## **FIRE SAFETY STUDY - ADDENDUM 1**

### **SMITHFIELD BATTERY ENERGY STORAGE SYSTEM**

**SSD-59325460**

**DOCUMENT NO: 21895-RP-002**

Civil Design
Layout Plan
Drawing No. 24219 - CW01 Rev. 3
Sheet No. 1 of 3 24219_CW01.dwg

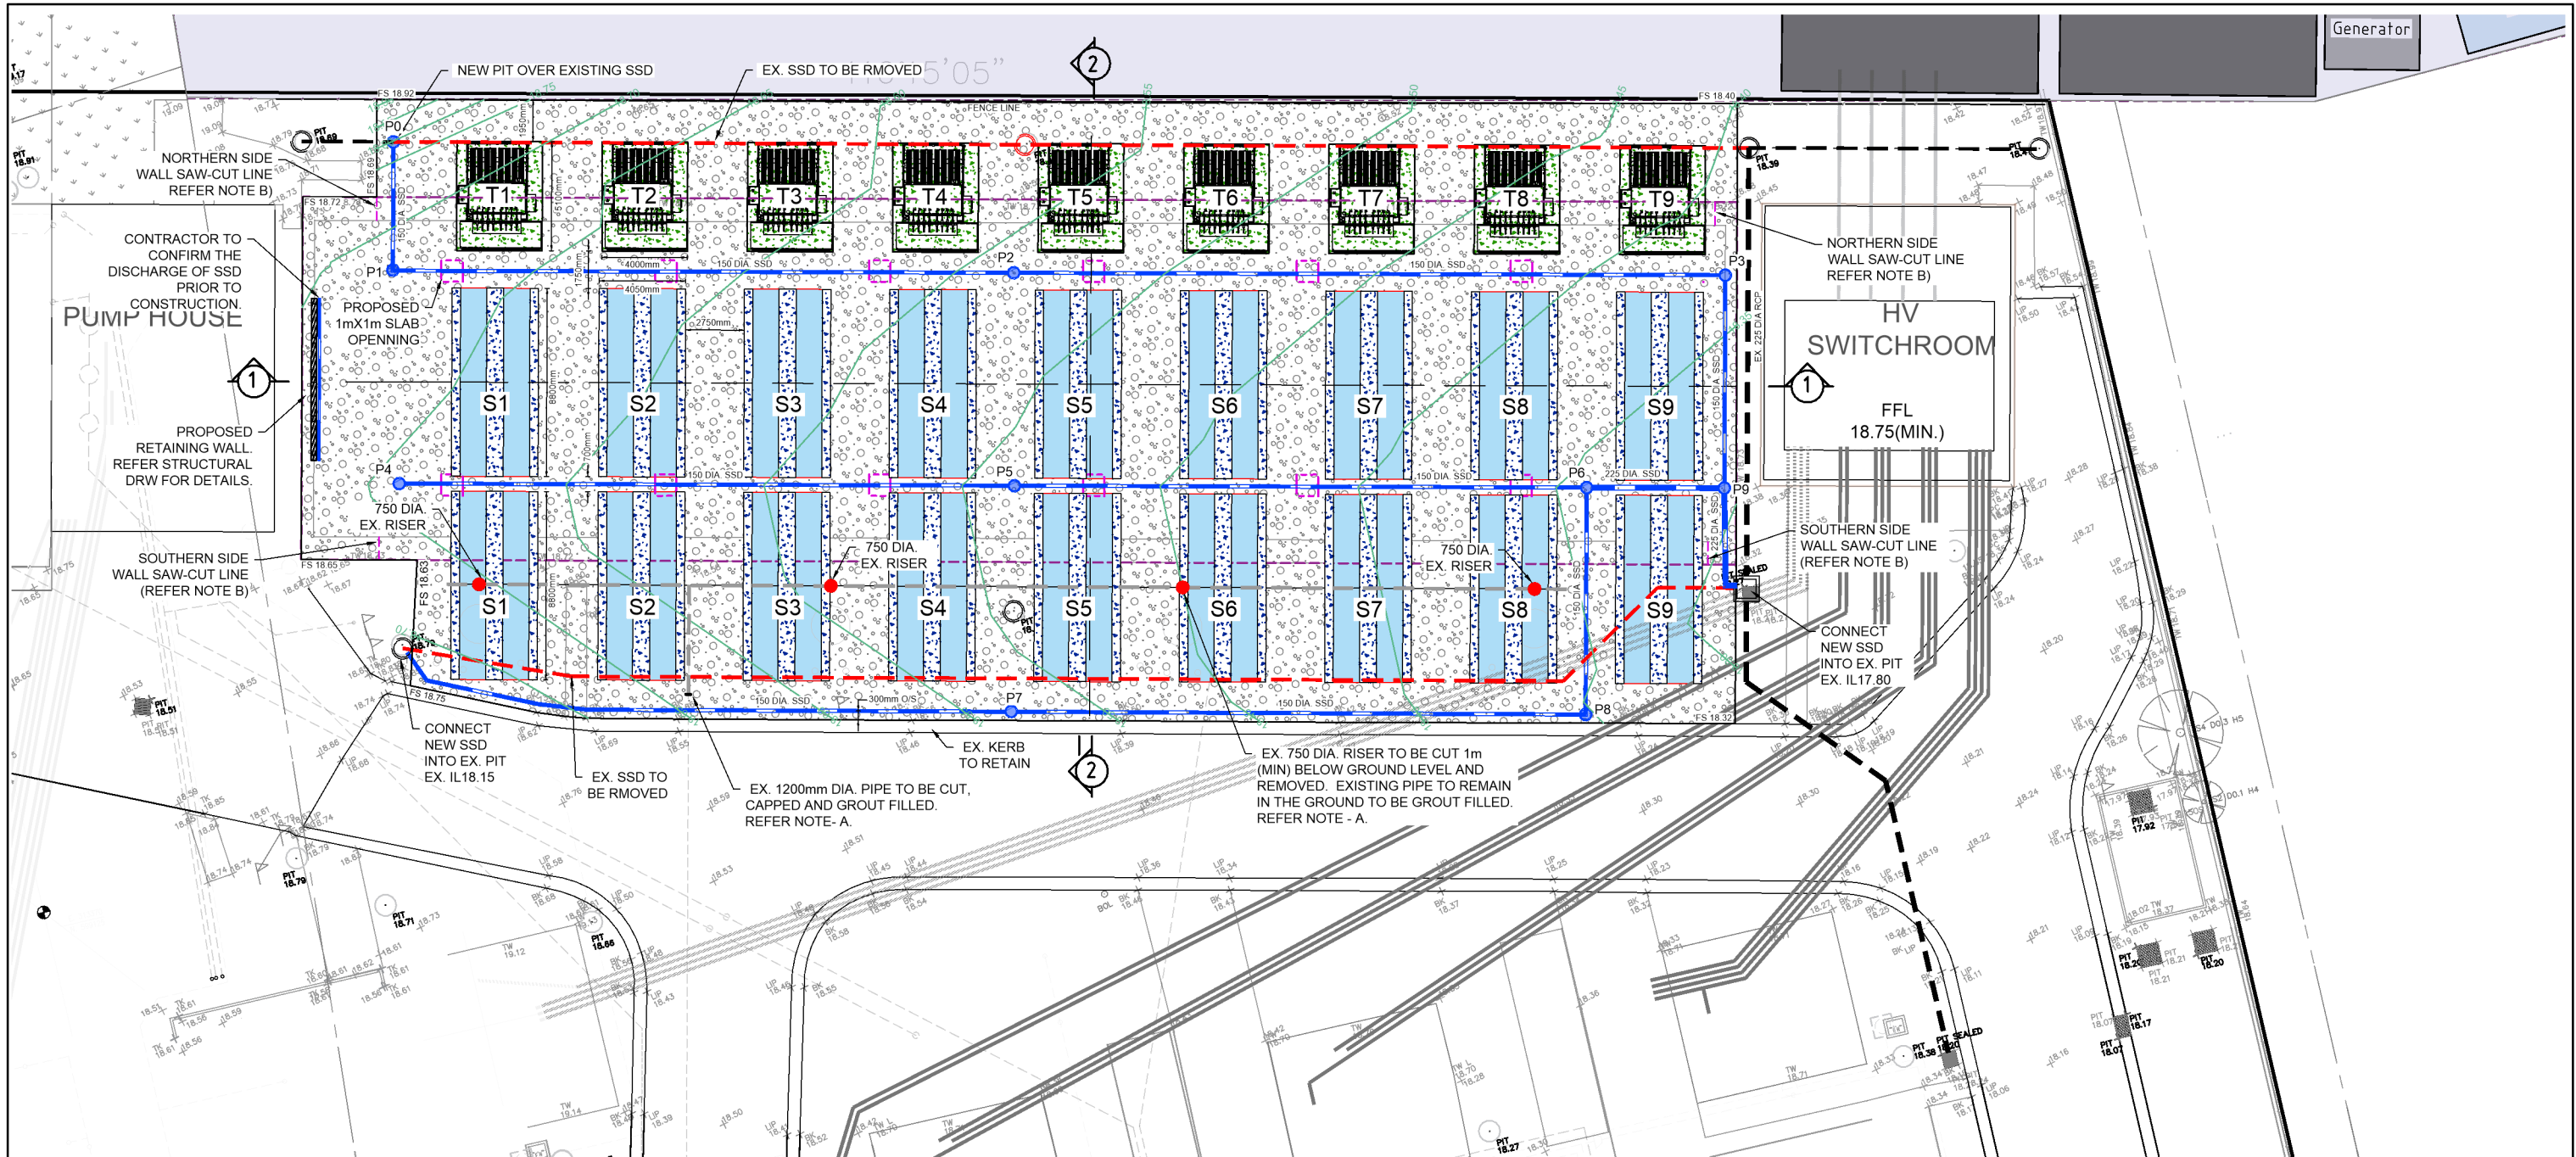
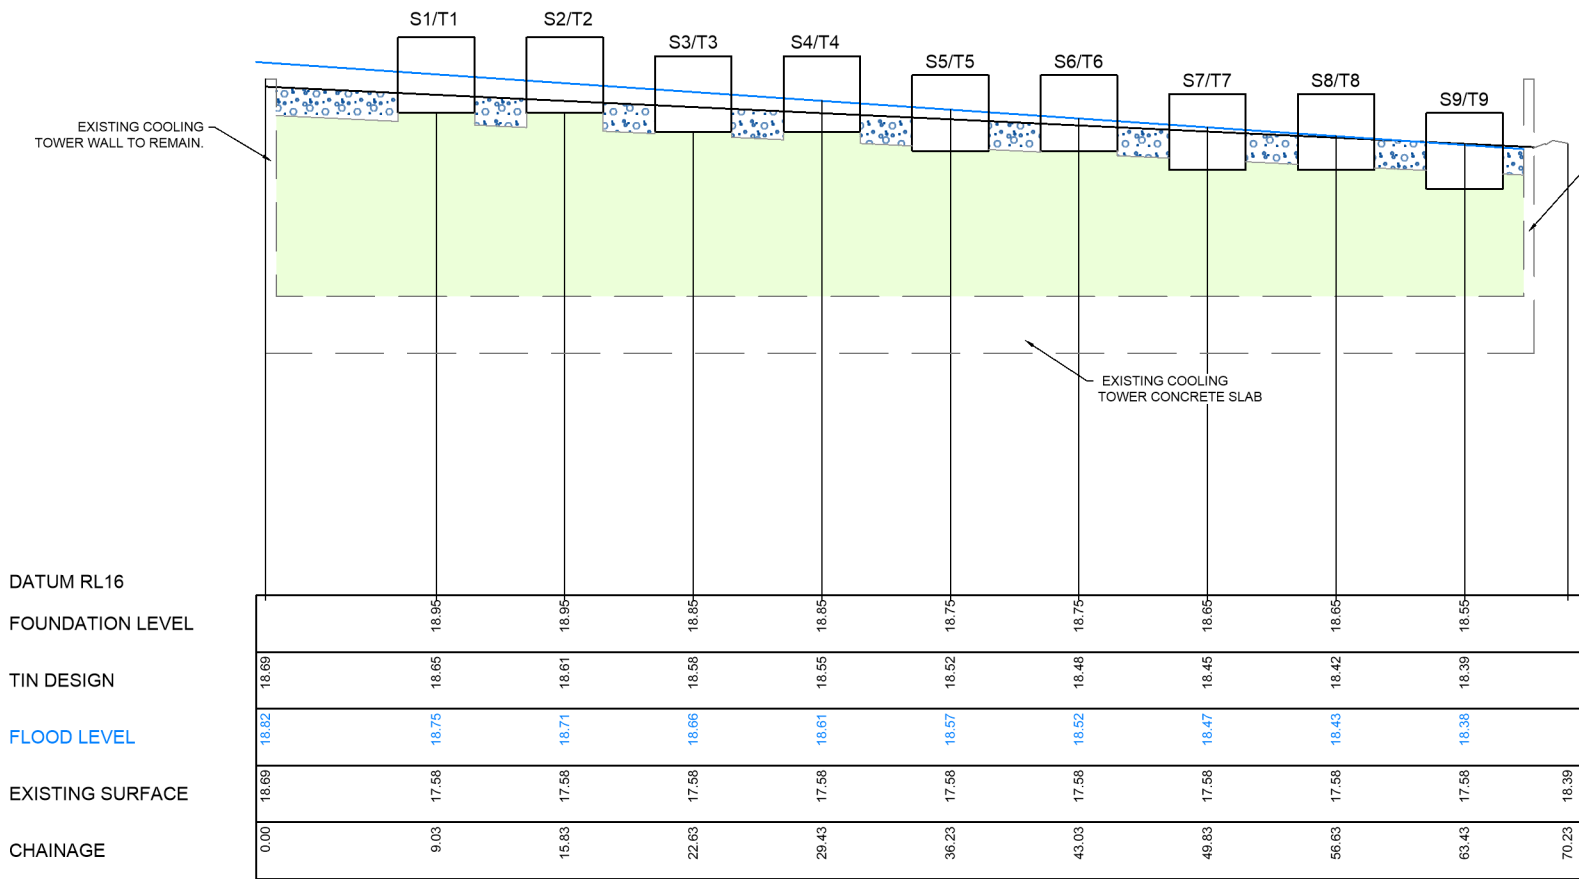
| FSS Section   | Fire Safety Study Comment<br>(provided by FRNSW)                                                                                                                                                                                                                                                                                                                                                                                                                                                                                    | FRNSW Comment                                                                                                                                                                                                          | Iberdrola Response                                                                                                                                                                                                                                                                                                                  |
|---------------|-------------------------------------------------------------------------------------------------------------------------------------------------------------------------------------------------------------------------------------------------------------------------------------------------------------------------------------------------------------------------------------------------------------------------------------------------------------------------------------------------------------------------------------|------------------------------------------------------------------------------------------------------------------------------------------------------------------------------------------------------------------------|-------------------------------------------------------------------------------------------------------------------------------------------------------------------------------------------------------------------------------------------------------------------------------------------------------------------------------------|
| Appendix C4.2 | The key inputs and assumptions are as follows:<br>• Surface area: equivalent to the transformer footprint (3.7m x 3.3m), with 25% assumed to be occupied by the transformer structure.                                                                                                                                                                                                                                                                                                                                              | FRNSW recommends confirming the provision of bunding for the BESS transformers to validate the assumption.                                                                                                             | Iberdrola has confirmed with the Transformer manufacturer that the bunding to be provided will hold the total volume of the transform oil (7,500 litres). The design bund volume is approximately 10,000 litres.                                                                                                                    |
